**Consultation Response from KC,
Highways Development Management**

2023/92882 4, Rowgate, Upper Cumberworth, Huddersfield, HD8 8XH

Demolition of existing dwelling and erection of detached dwelling with basement parking

Date Responded: 16-10-2023.

EXISTING SITE PLAN

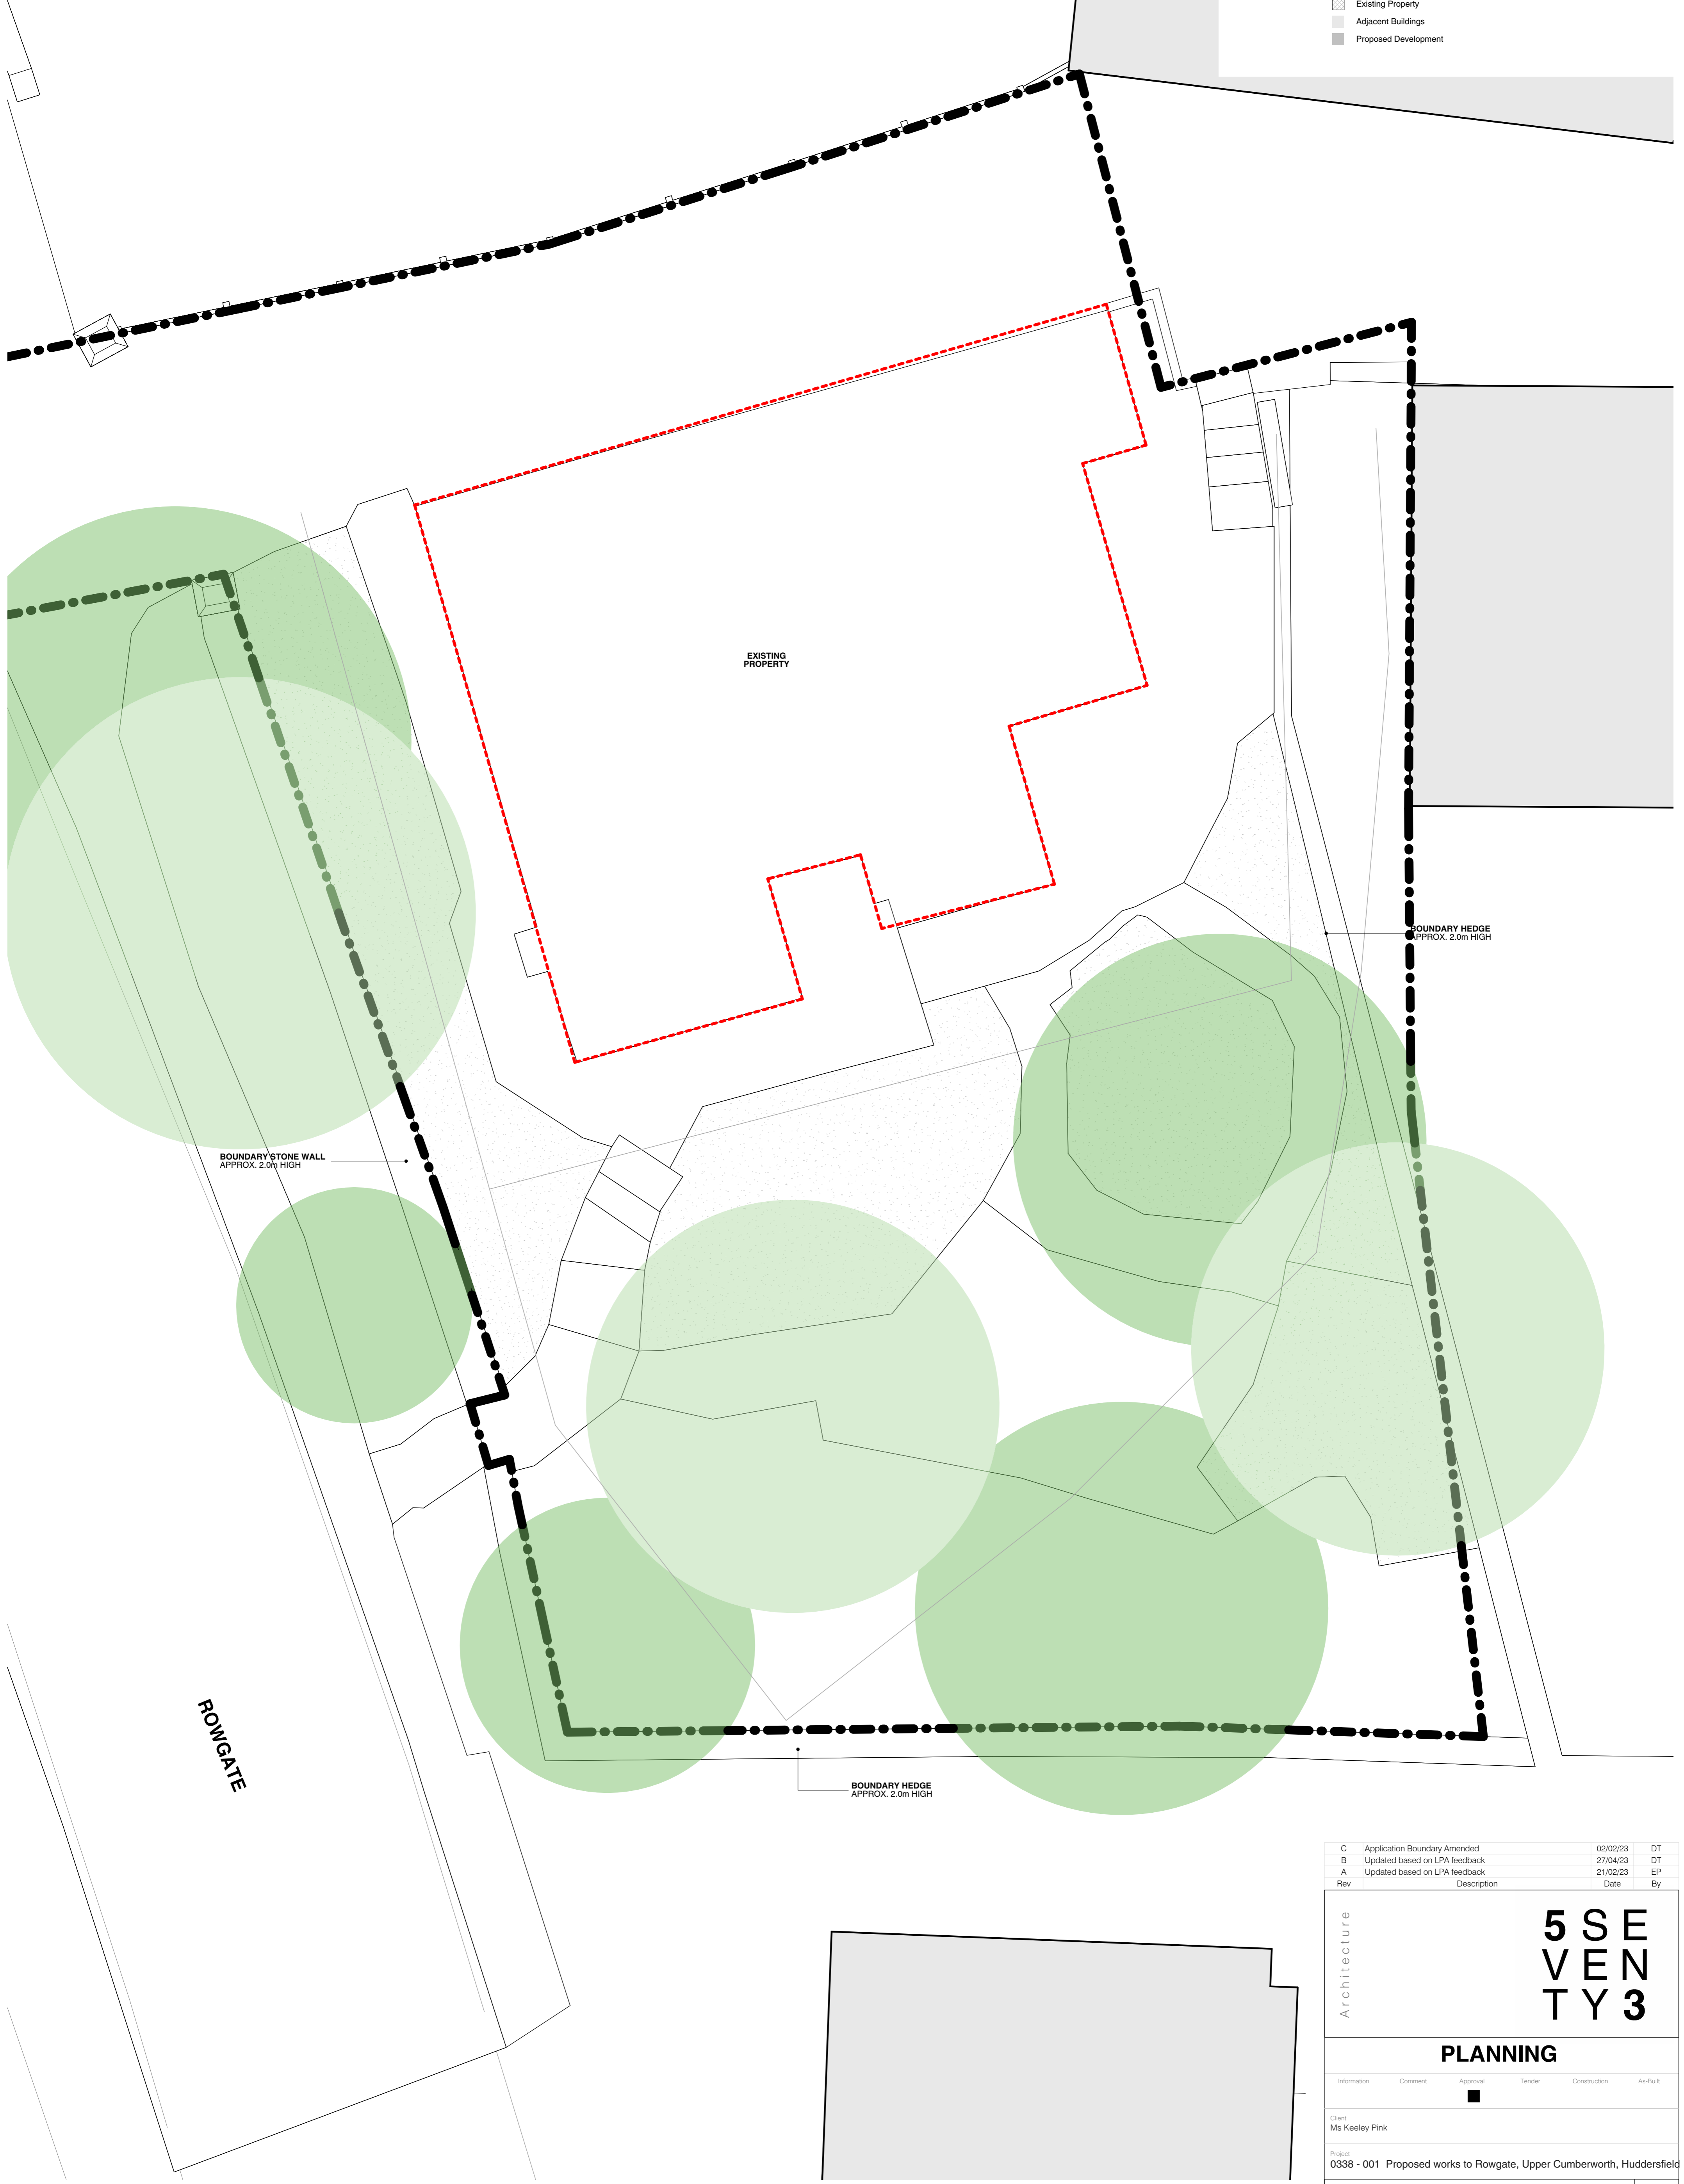
- 1, The access from Rowgate is not within the red line boundary.
- 2, A bin collection points should be shown to be provided to enable bins to be presented on collection day without either obstructing the highway or proposed driveway.
